**Erection of 1 Number Dwelling with Detached Garage
Land at The Entrance to Watersford Gardens, Horsemere Green Lane
Planning Reference CM/23/17/PL. Case Officer Mrs A Gardner**

We write with reference to the proposed renewal of the planning application for the erection of one number additional four-bedroom dwelling and double garage on land at the entrance to Watersford Gardens reference CM/23/17/PL.

Site Plan

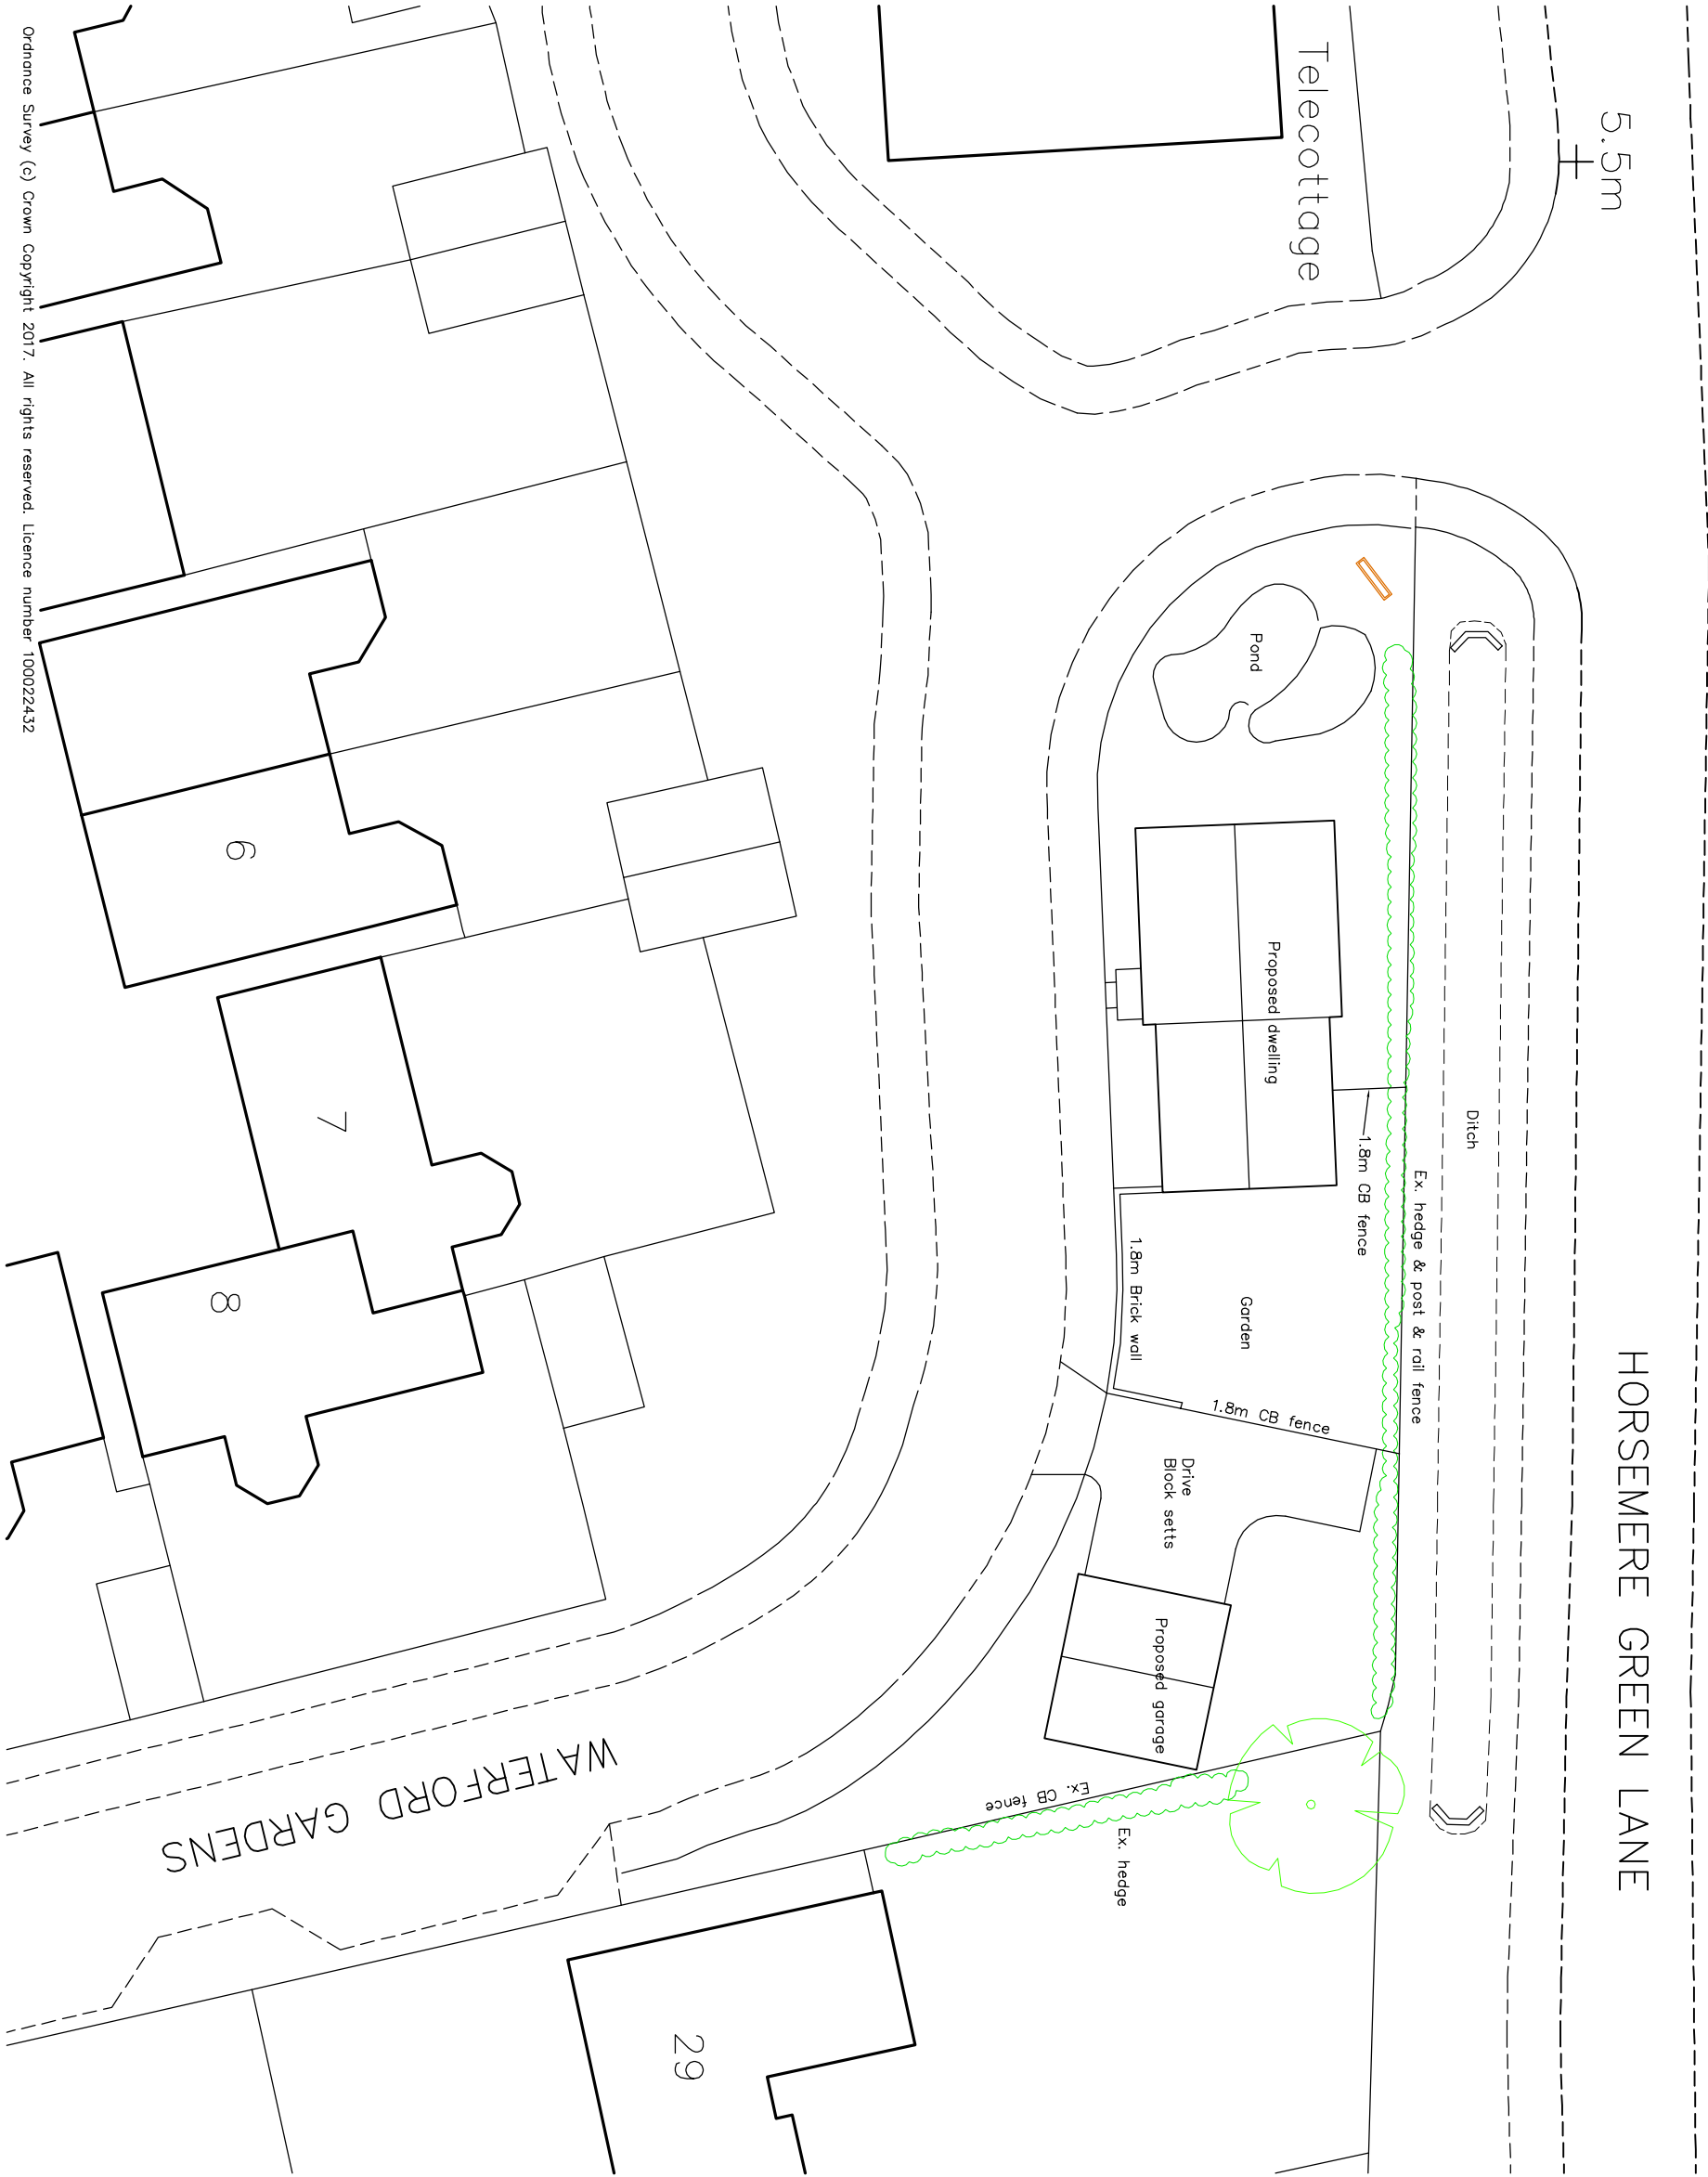
- 5) ADP Architects Drawing 1408 02 dated February 2008 and Drawing 1408 100 dated February 2017 do not match and are not consistent.
- 6) There is no Planning, Design, Access Statement and No Lighting Assessment has been completed or submitted.

Double Garage

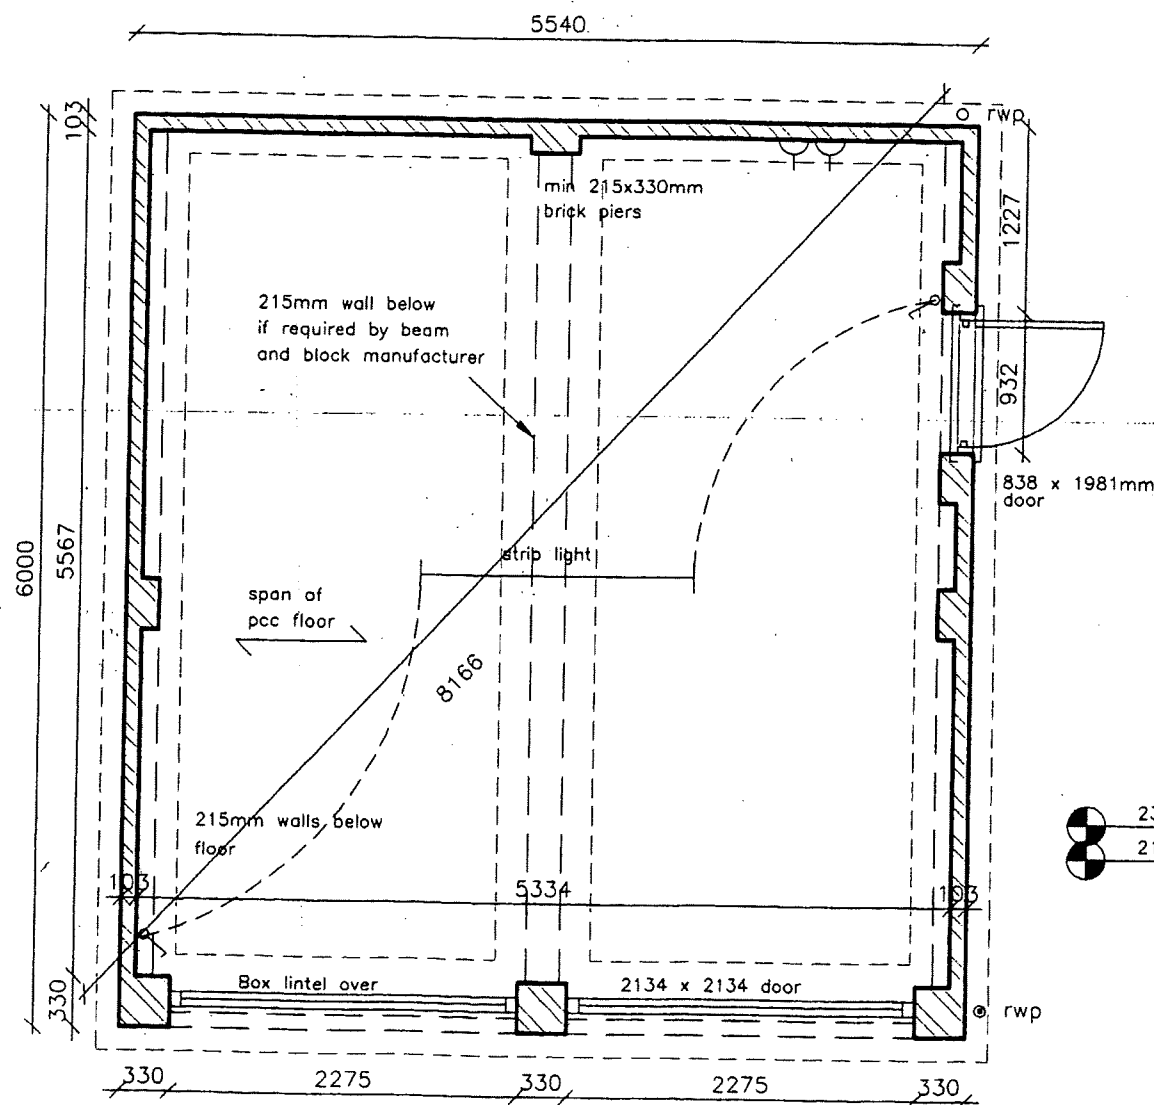
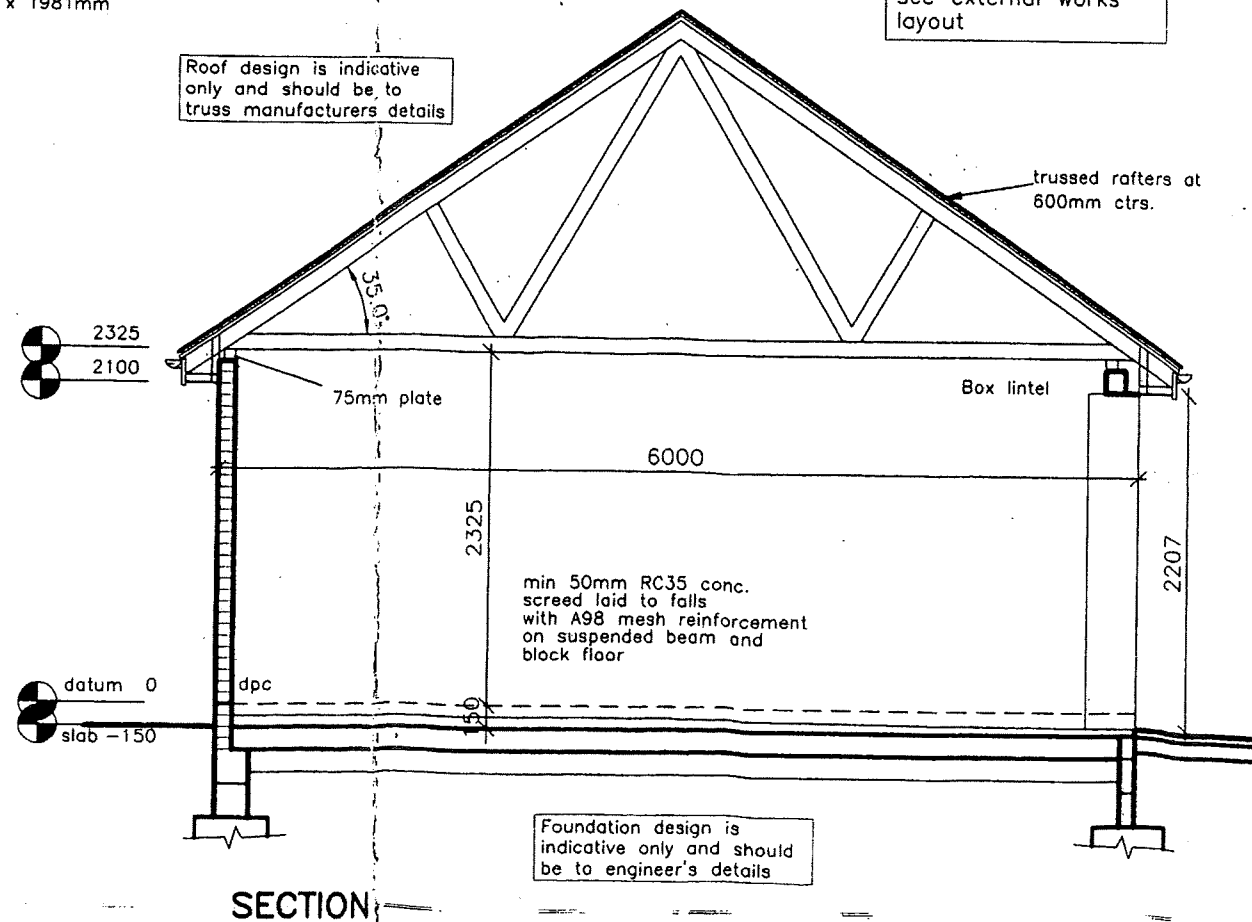
- 12) Domination of adjoining property at 29 Crophorne Drive with the proposed garage height of 4.7m. This will be 2.9m above the height of the boundary fence.

14) Proximity of the proposed double garage to 29 Crophorne Drive.
